**Planning Department
Transportation Development Services Section**

August 13, 2010

Re: Certification Submittal for a Permanent Building Certificate of Occupancy
(C.O.) for Kelly Liquor's, [B-10/ D0003C2]
6531 Paradise Blvd. NW
Architect's Stamp Dated 08/09/10

SHEET NUMBER  
C-1

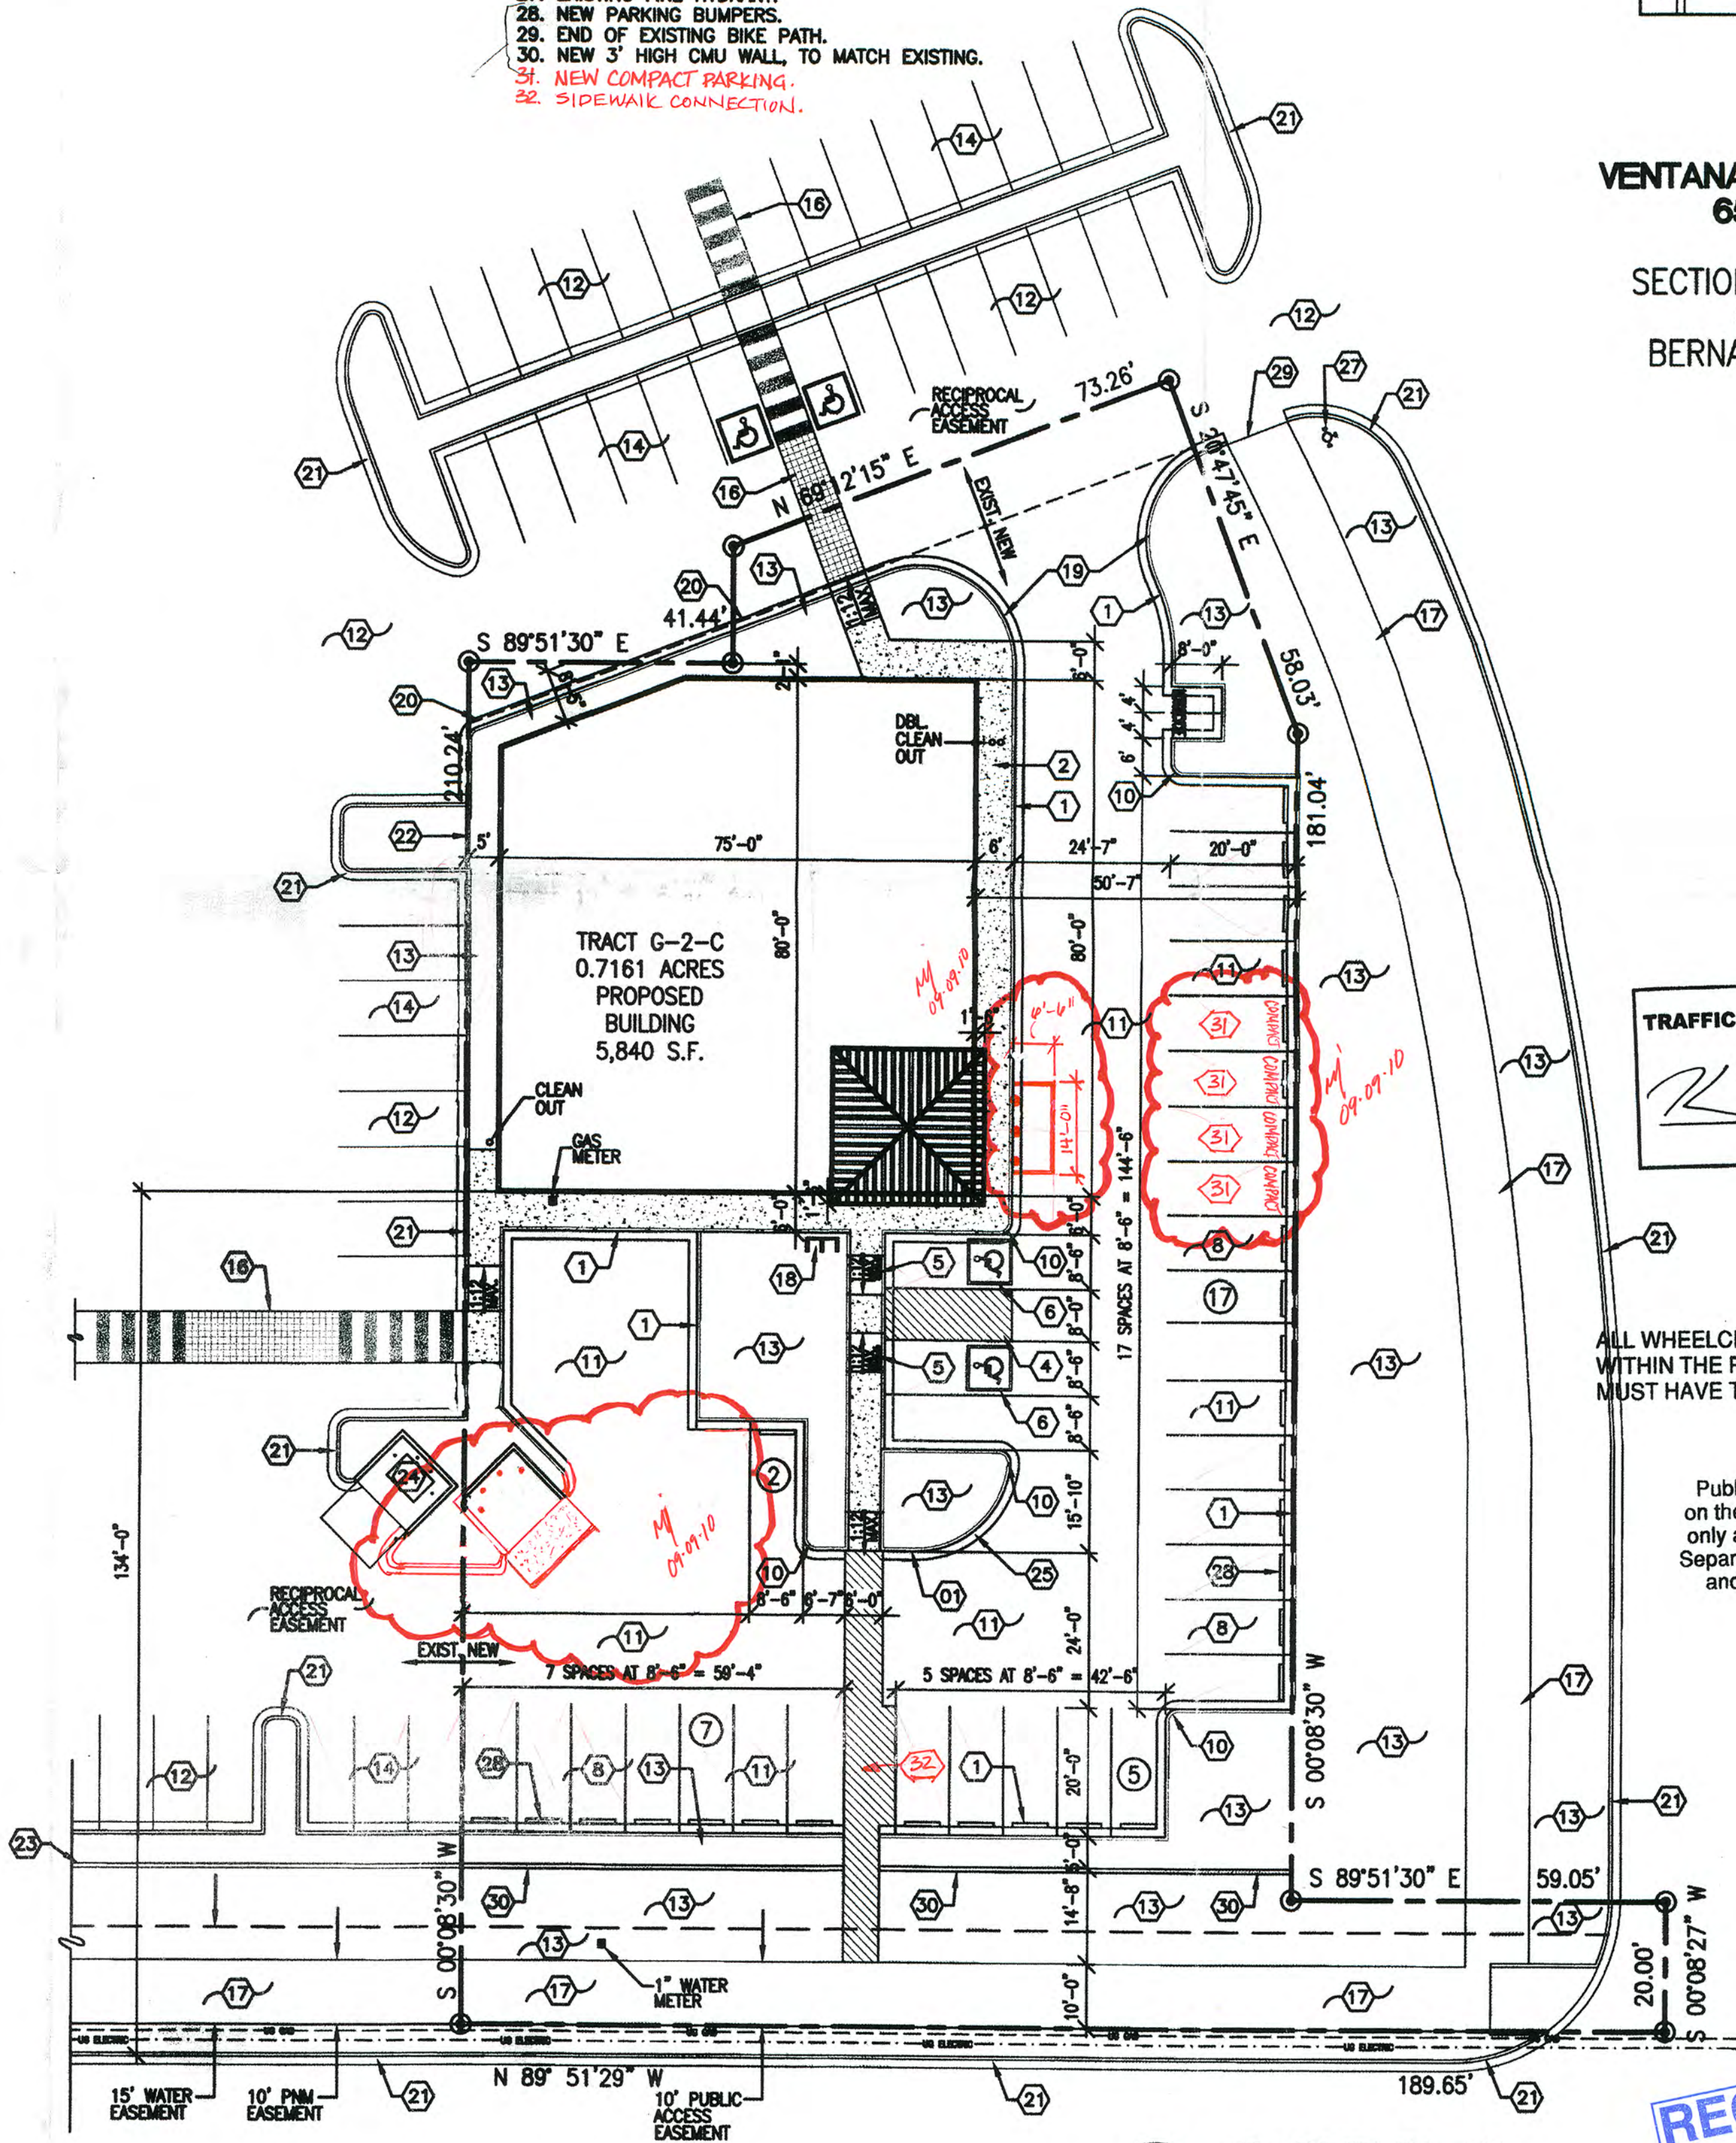
The following items will need to be addressed prior to issuance of a Permanent/temporary Certificate of Occupancy: **There are missing parking bumpers (parking stalls facing KFC site and delivery area) and required bumpers (at ADA parking stalls) which need to be installed per Site Plan key notes; remove dirt mount and barricade from northern parking stalls; please show new ramp with bollards in front of store entrance (provide dimensions of ramp and adjusted aisle width and mark the stalls as COMPACT (which are affected by the ramp and ramp will need to be painted yellow at entrance lip); all ramps and sidewalk connections need to be ADA accessible onto site (which they are not ADA accessible).** Once, these issues have been addressed you'll need to re-submit the total package for Permanent C.O. **(please redline all changes on the approved Site Plan as part of the re-submittal package).**
